MMC Parking Garage - Final Traffic Comments

From: **Tom Errico** <thomas.errico@tylin.com>
Date: Tue, Aug 14, 2018 at 9:20 AM
Subject: MMC Parking Garage - Final Traffic Comments
To: Helen Donaldson <HCD@portlandmaine.gov>
Cc: Bruce Hyman <bhyman@portlandmaine.gov>, Jeremiah Bartlett <JBartlett@portlandmaine.gov>

Hi Nell – I have conducted comprehensive review of current application materials and offer the following final traffic comments as a status update of prior comments.

CONSIGLI

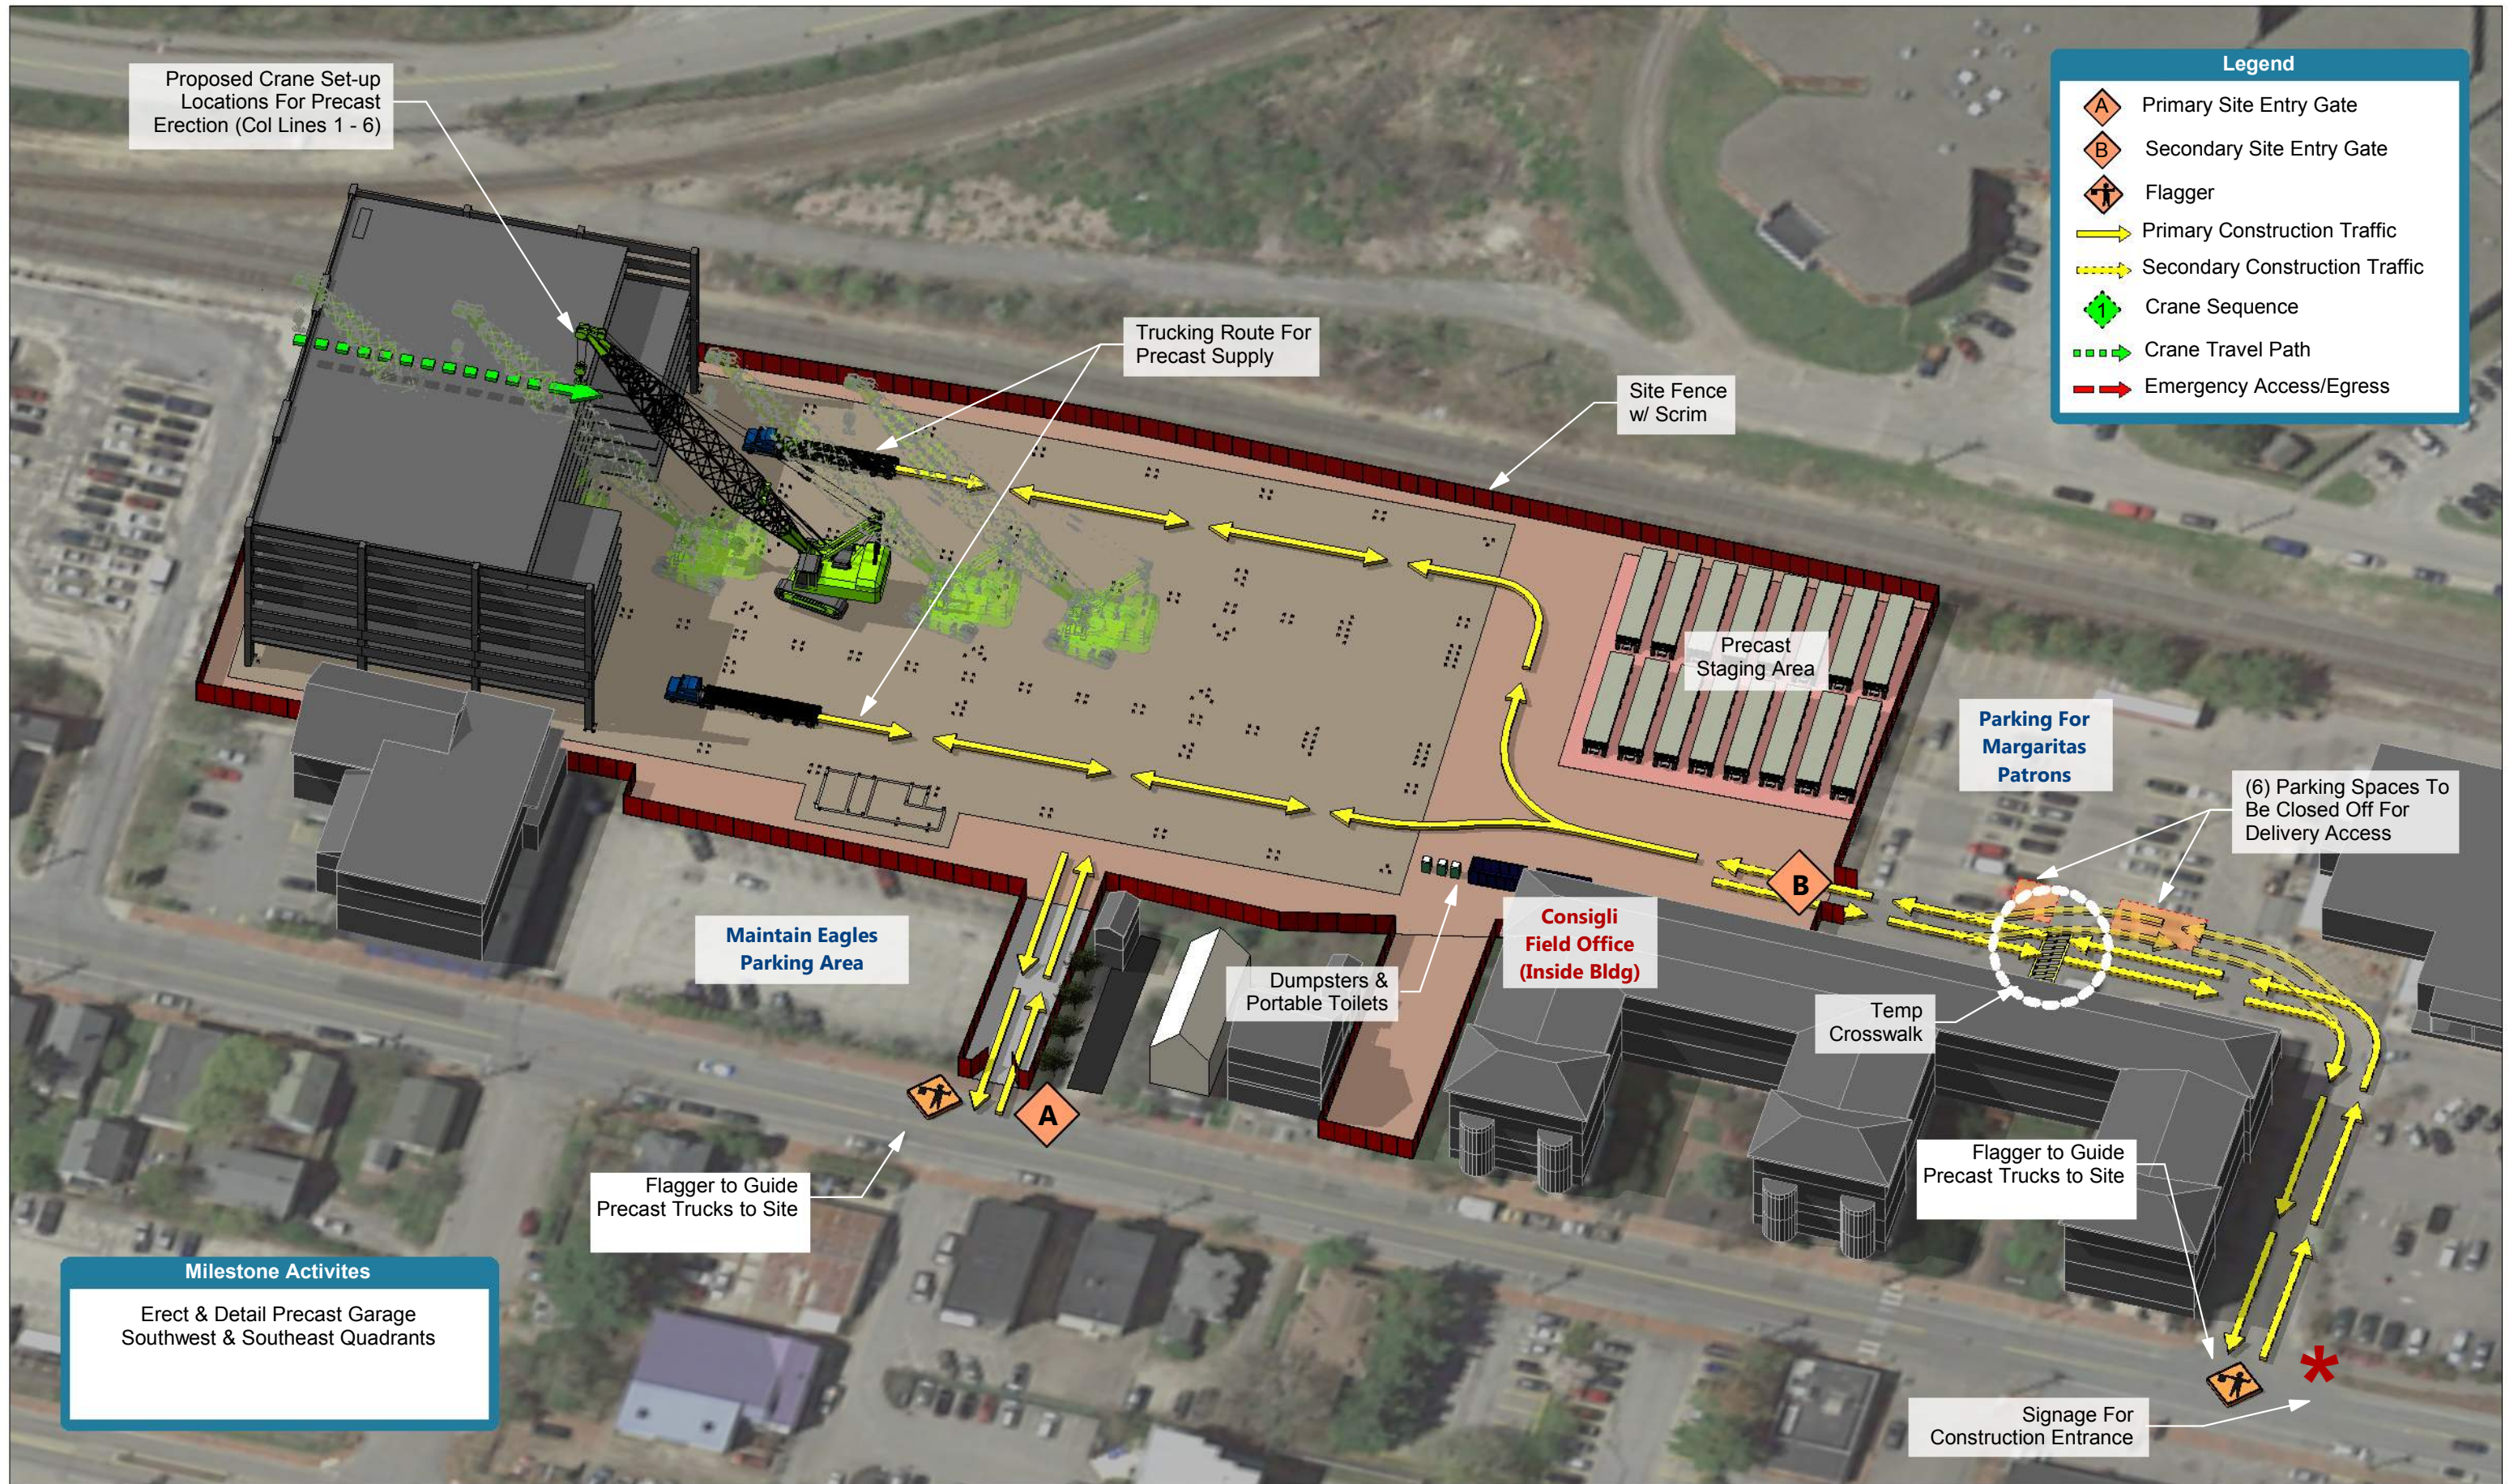
- **Construction Management Plan**
 - **Construction trucks time limits shall be extended to include both MMC and general traffic peak hours.**
 - **The secondary storage yard shall be specifically identified.**
 - **The applicant should note how will the Eagles parking demand be accommodated during construction.**
 - **All temporary crosswalks shall be ADA compliant.**
 - **Construction plans shall be provided for the roadway/signal work in St. John Street, D Street, and Valley Street.**
- **The applicant shall narrow the Eagles driveway width to match the aisle width.**
- **The Eagles existing parking lot shall provide an aisle width dimension.**
- **The applicant shall provide the grade of parking ramps within the garage.**

Drawing file: Plans / 30 PS6 Level Parking Layout.pdf

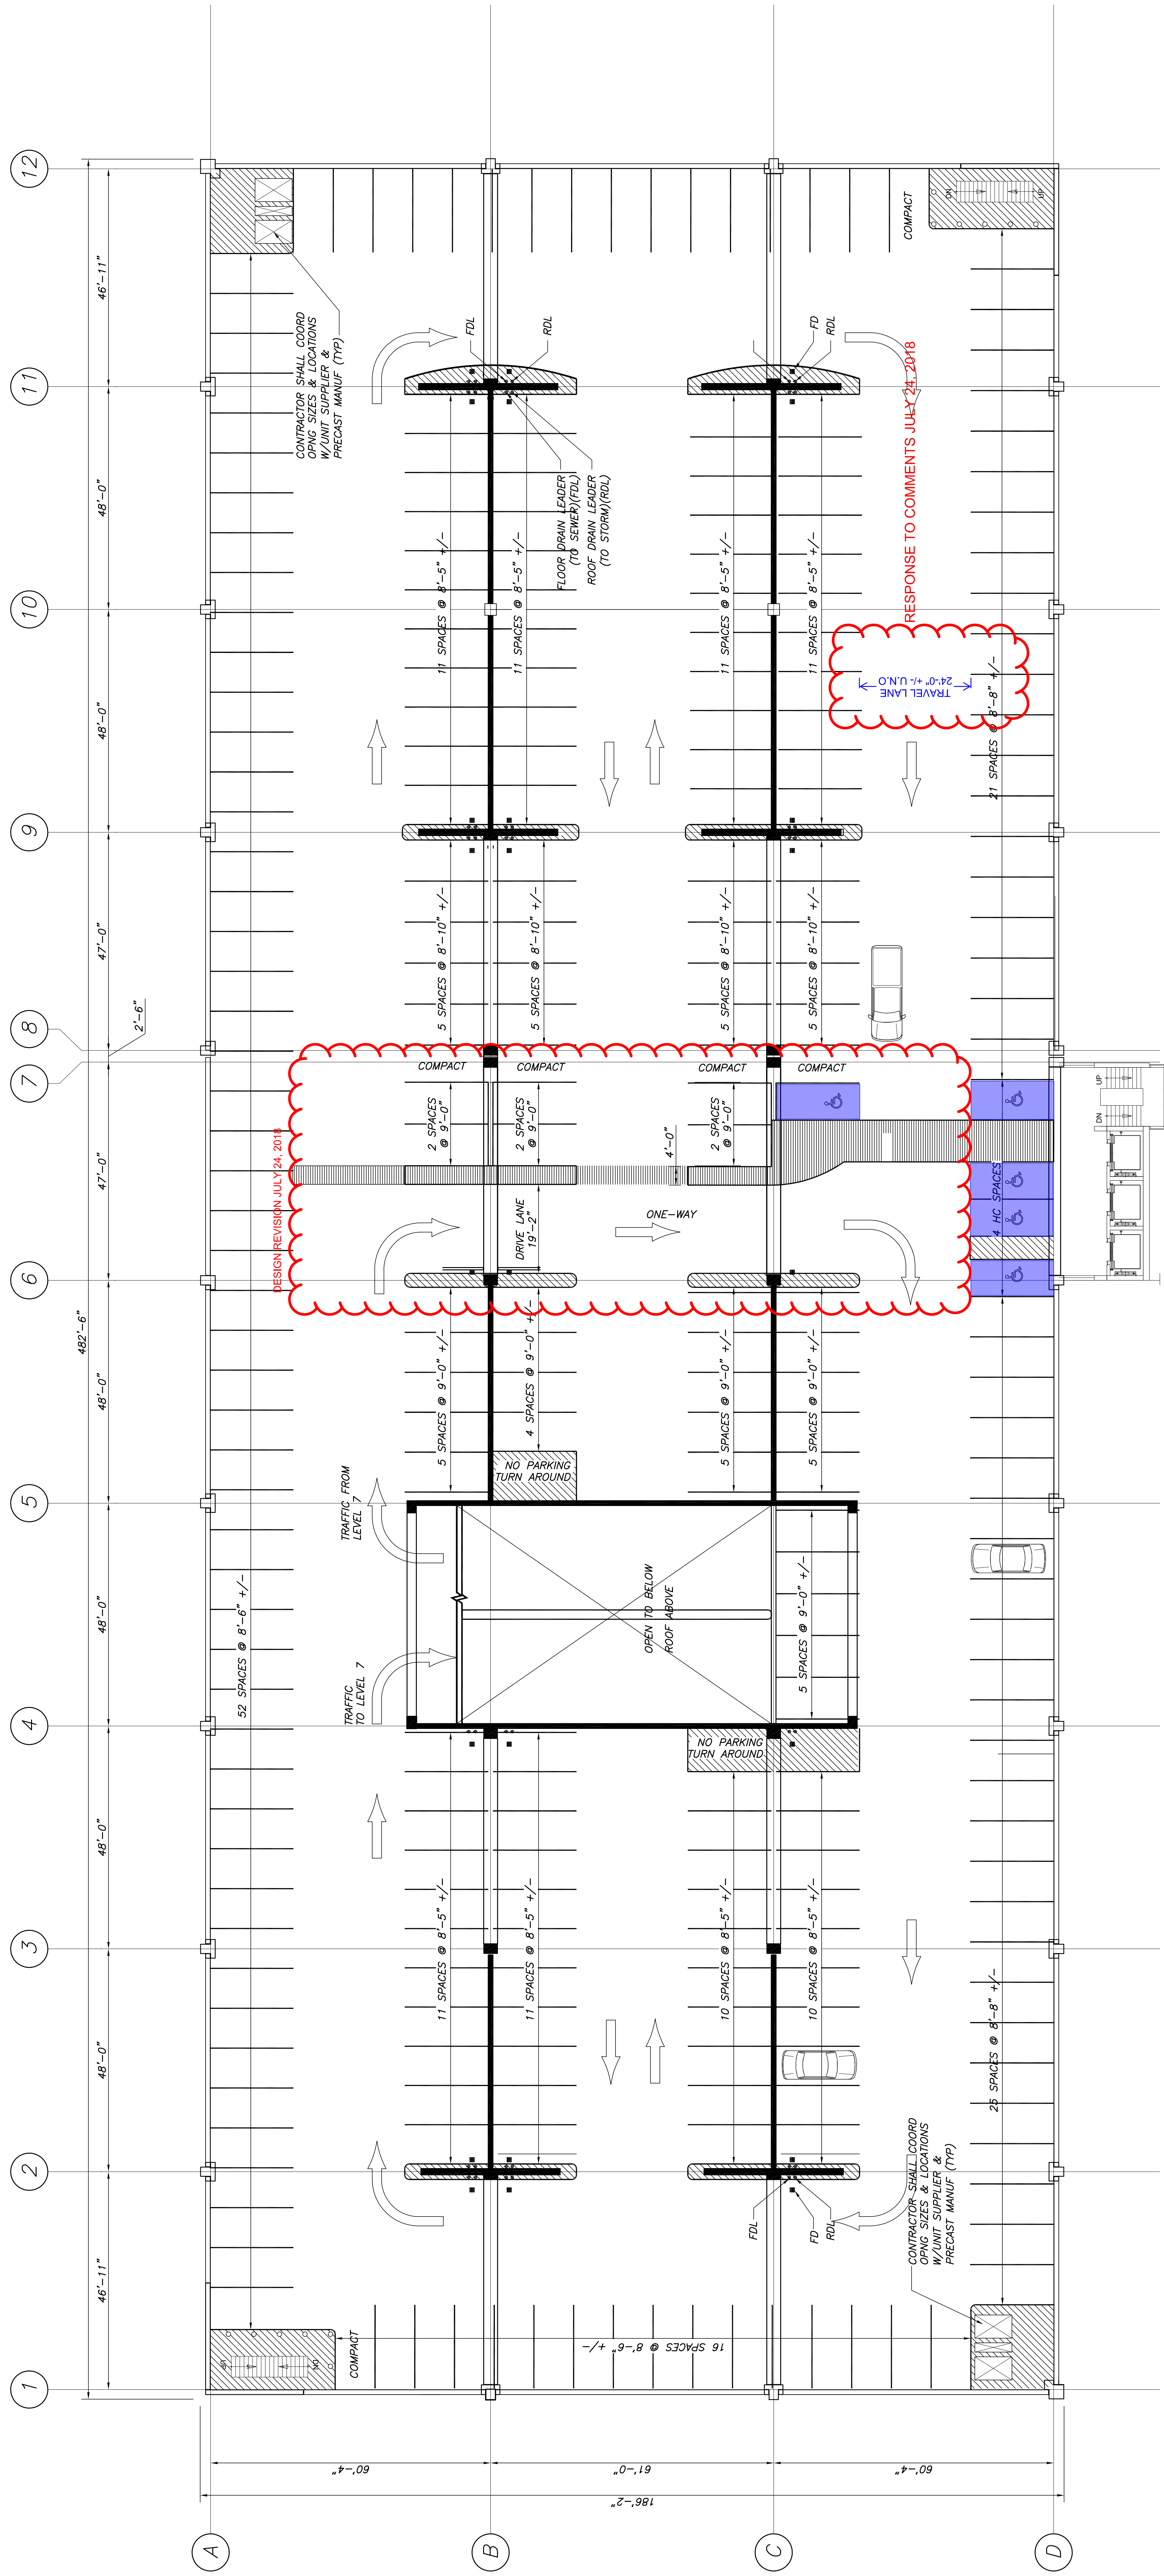
- The parking garage has a number of spaces that do not meet the City's dimensional standards for size. The applicant should request a formal waiver with supporting documentation.

- The garage plans should include dimensions for parking aisle widths.

Status: The applicant has provided supporting information and given long-duration parking conditions, I support a waiver from the City's Technical Standards.

Status: The plans include aisle widths and some do not comply with City standards. The applicant should request a formal waiver with supporting documentation.
